Rezoning Transportation Analysis

Petition Number: #2022-125

Revision Log:

Date	Description
12-29-22	First Review (TM)
01-27-23	Second Review (DR)
02-23-23	Third Review (TM)
03-30-23	Fourth Review (TM)

RZ-2

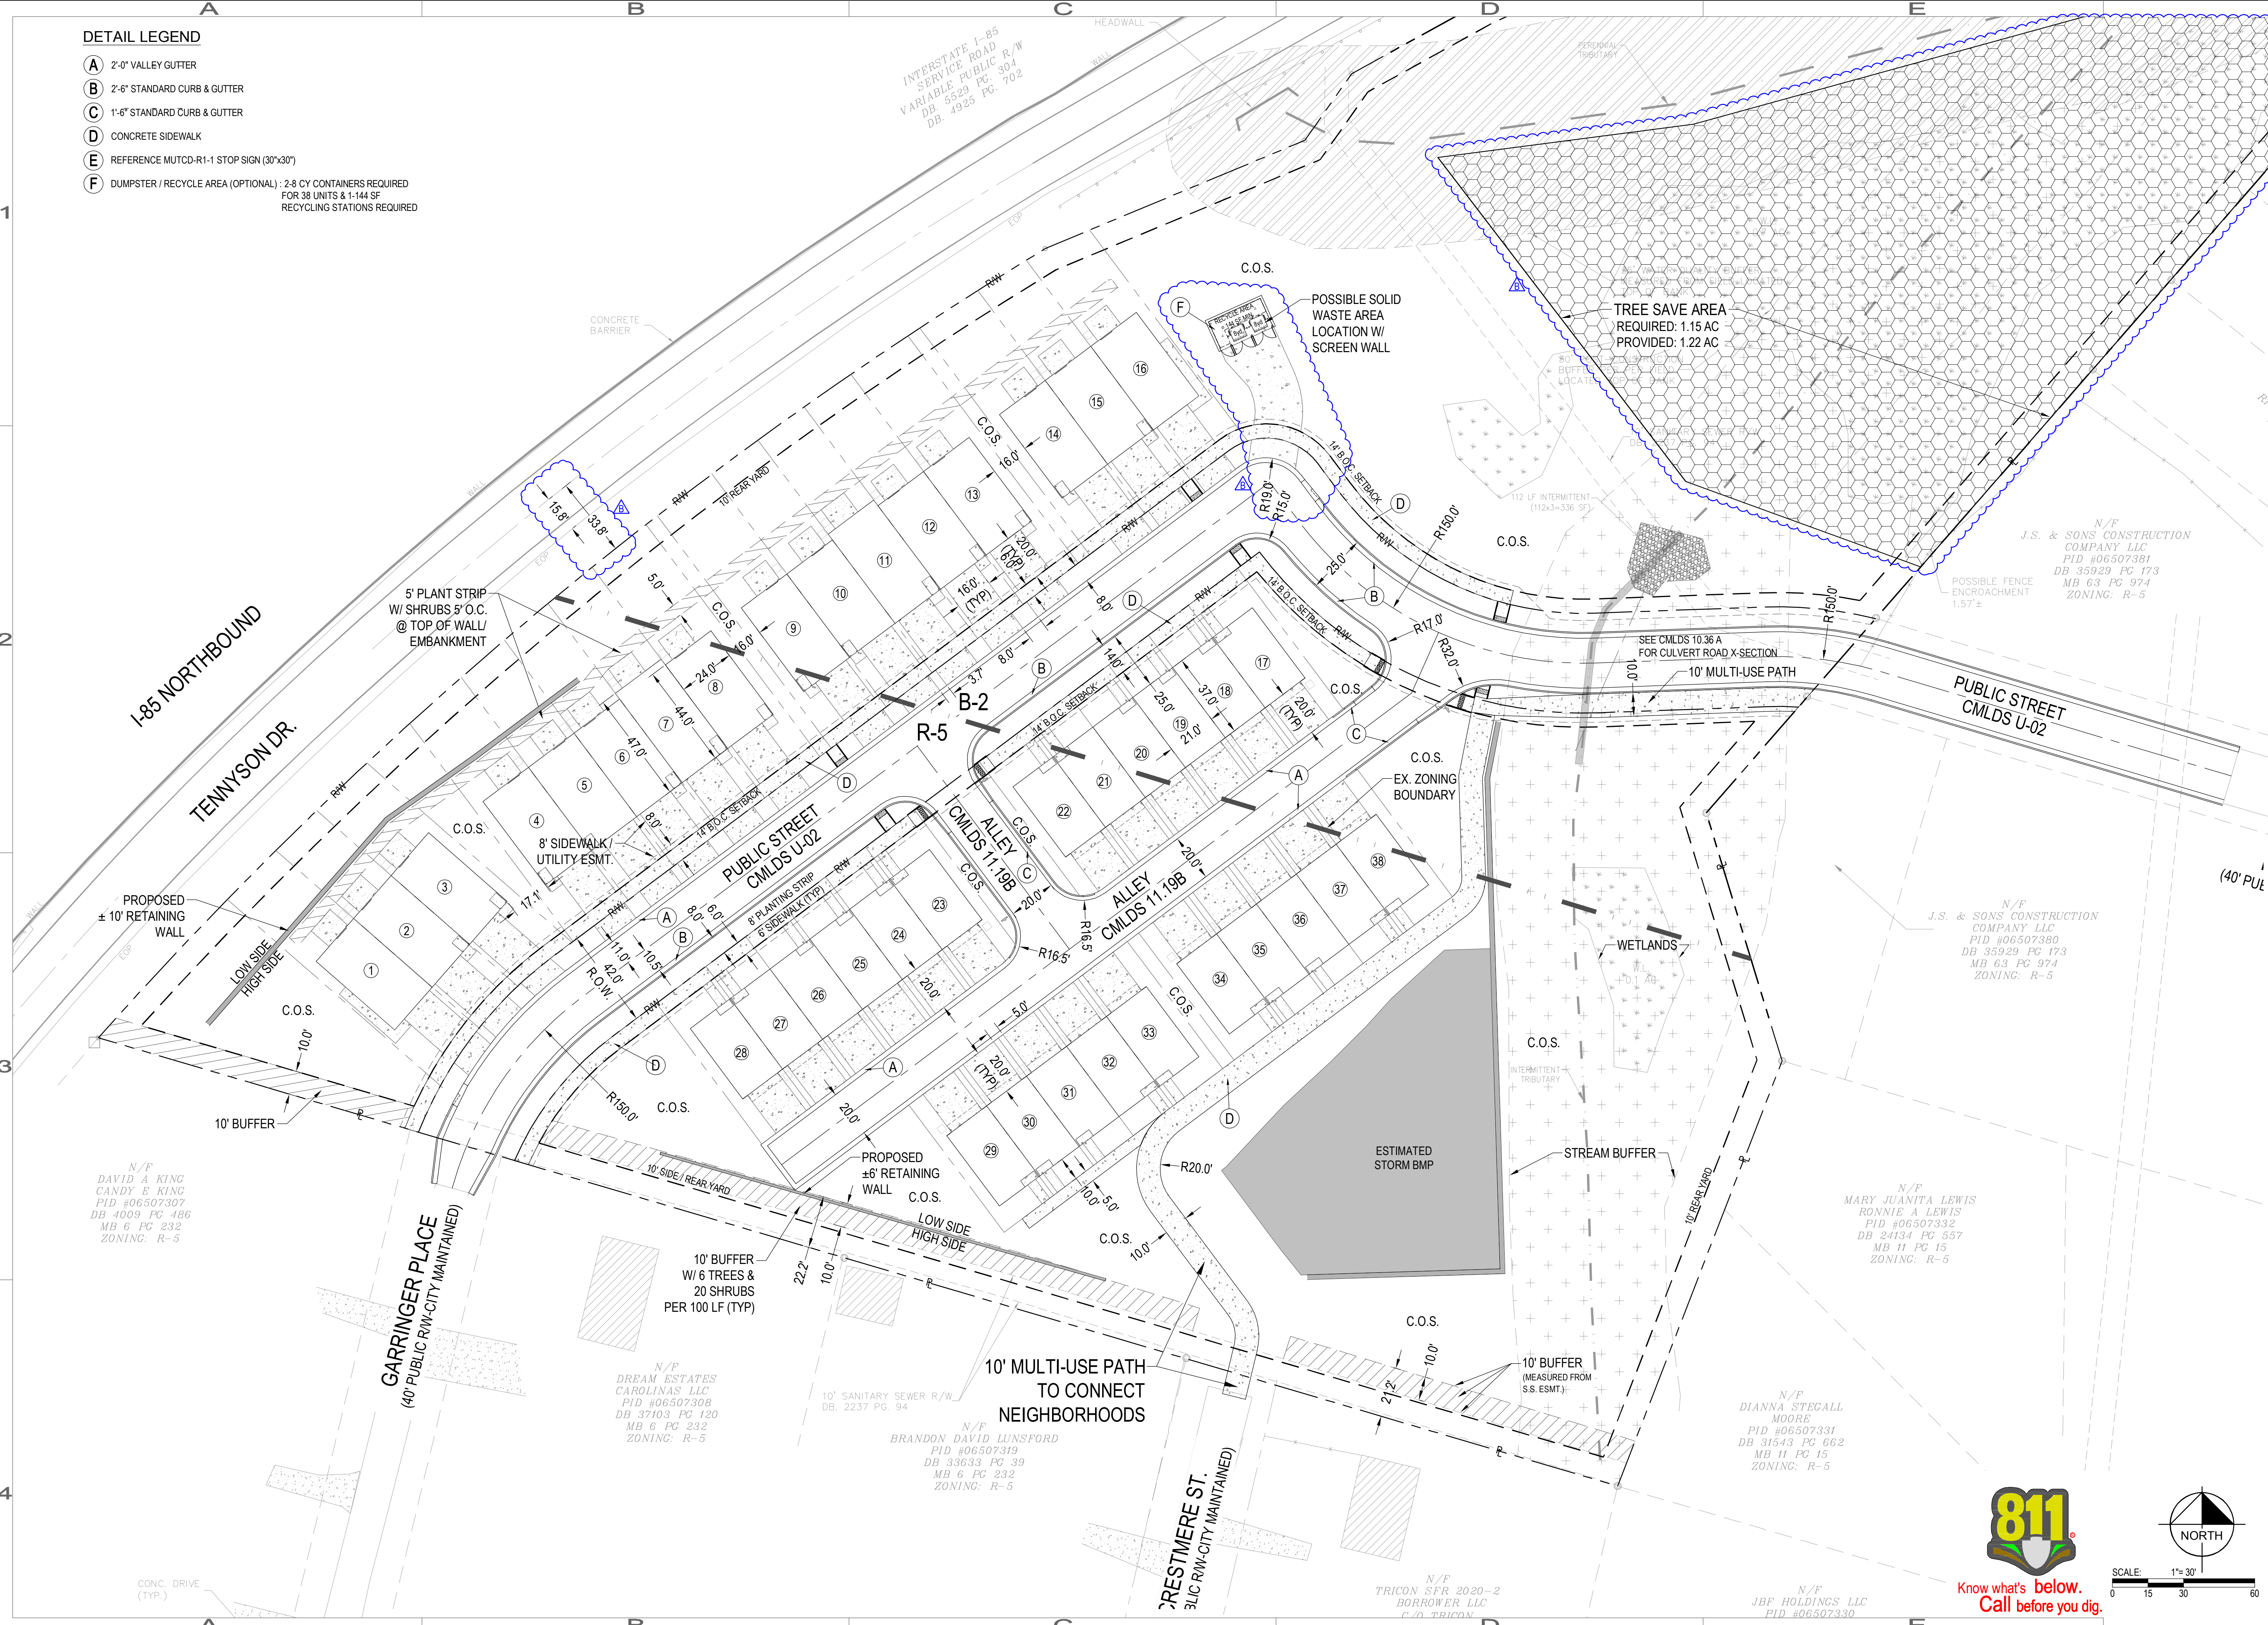
Clarifying Comment 01-27-23: CDOT will not accept current design. Revise roadway to remove 90 degree turn and satisfy CDOT standards for public roadway geometry. Remove crosswalk, stop bars, and stop signs.

11. **NEW CDOT COMMENT (02-22-23):** CDOT will not accept current design. Revise roadway to remove 90 degree turn and satisfy CDOT standards for public roadway geometry.
